re: Grading Plan Review
Proposed Commercial Development
480 & 486 Citigate Drive – Ottawa, Ontario

date: October 10, 2023

file: PG6514-MEMO.03

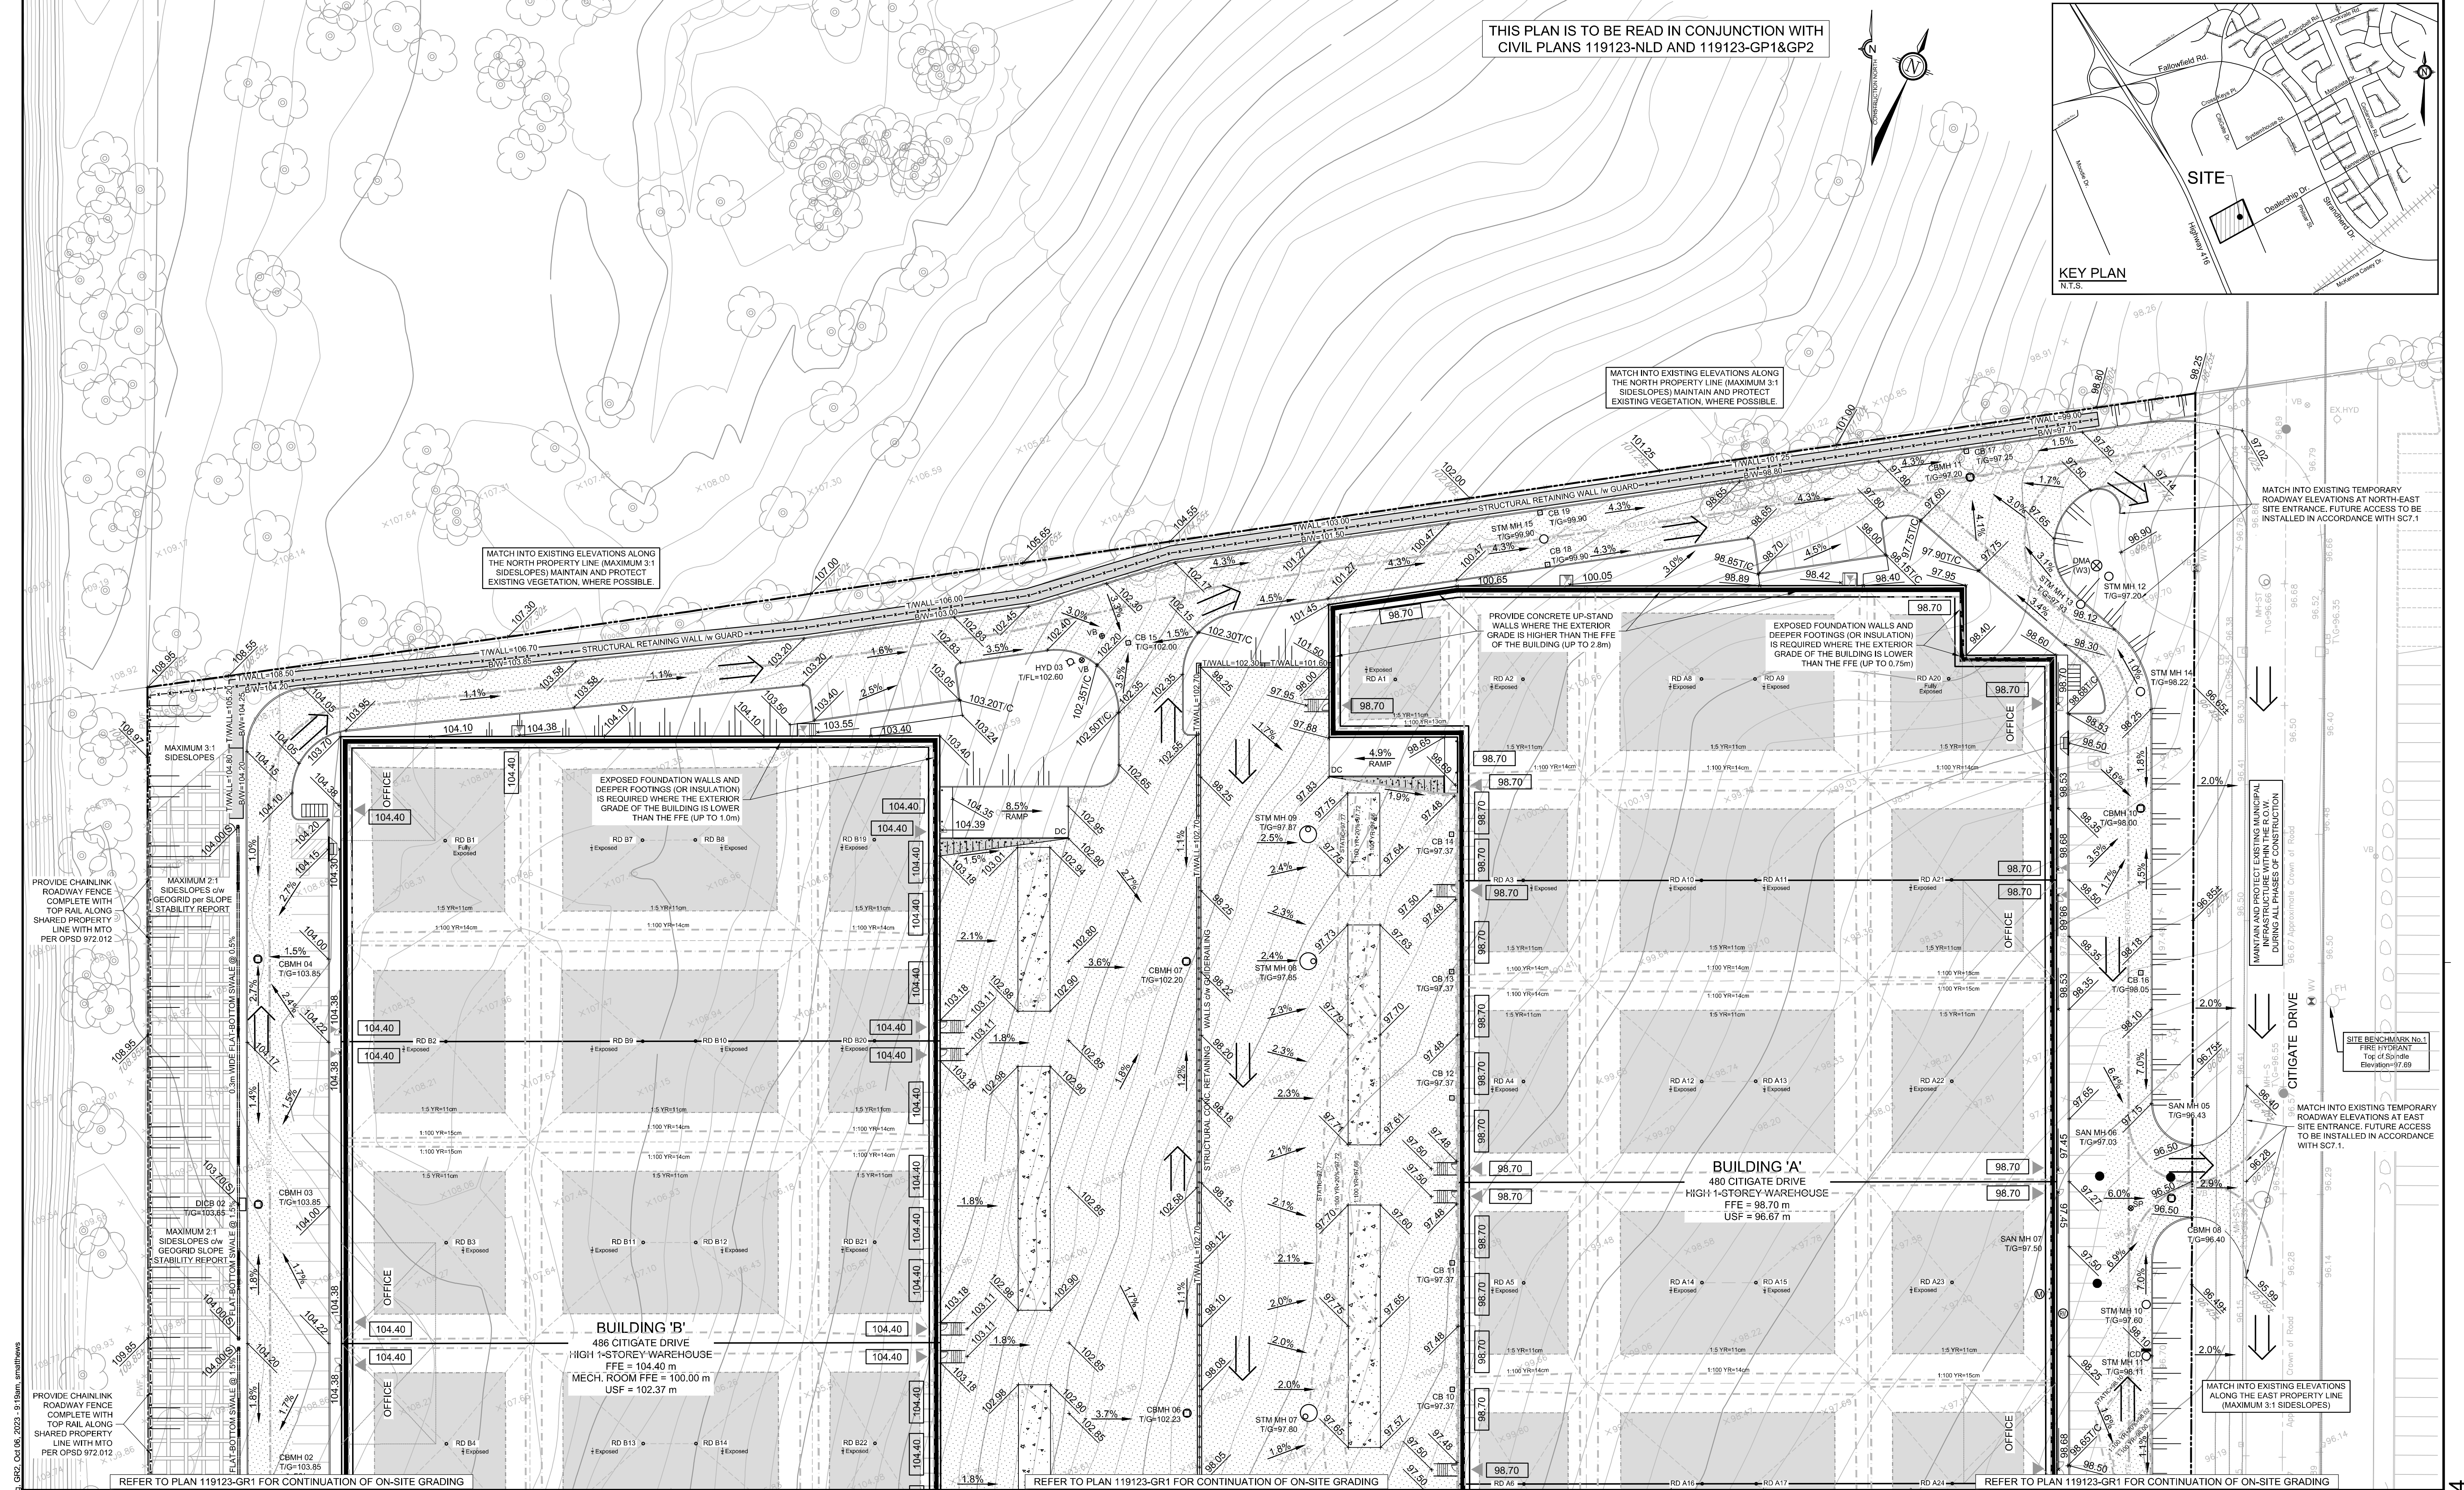
Based on our review of the above noted grading plans, the proposed grade raises within the aforementioned site are within the recommended permissible grade raise of 2.0 m. No exceedances were noted for any area within the subject site. Therefore, the proposed grade raises are generally acceptable from a geotechnical perspective and will not require the use of lightweight fill at this time.

Perimeter footings of heated structures are required to be insulated against the deleterious effects of frost action. A minimum 1.5 m thick soil cover (or insulation equivalent) should be provided in this regard.

Other exterior unheated footings, such as those for isolated exterior piers, footings located below loading docks, and loading dock ramp wing-wall are more prone to deleterious movement associated with frost action than the exterior walls of the proper structure. These footings should be provided with a minimum 2.1 m thick soil cover (or insulation equivalent).

Where footings are founded directly on clean, surface-sounded bedrock with no near-surface cracks or fissures and are approved by Paterson personnel at the time of the excavation, the minimum soil cover, listed above, is not required.

It is recommended that Paterson review the proposed footing and/or insulation details once the final detail design drawings are available for the above noted items prior to construction to ensure the effects of frost action are mitigated appropriately.
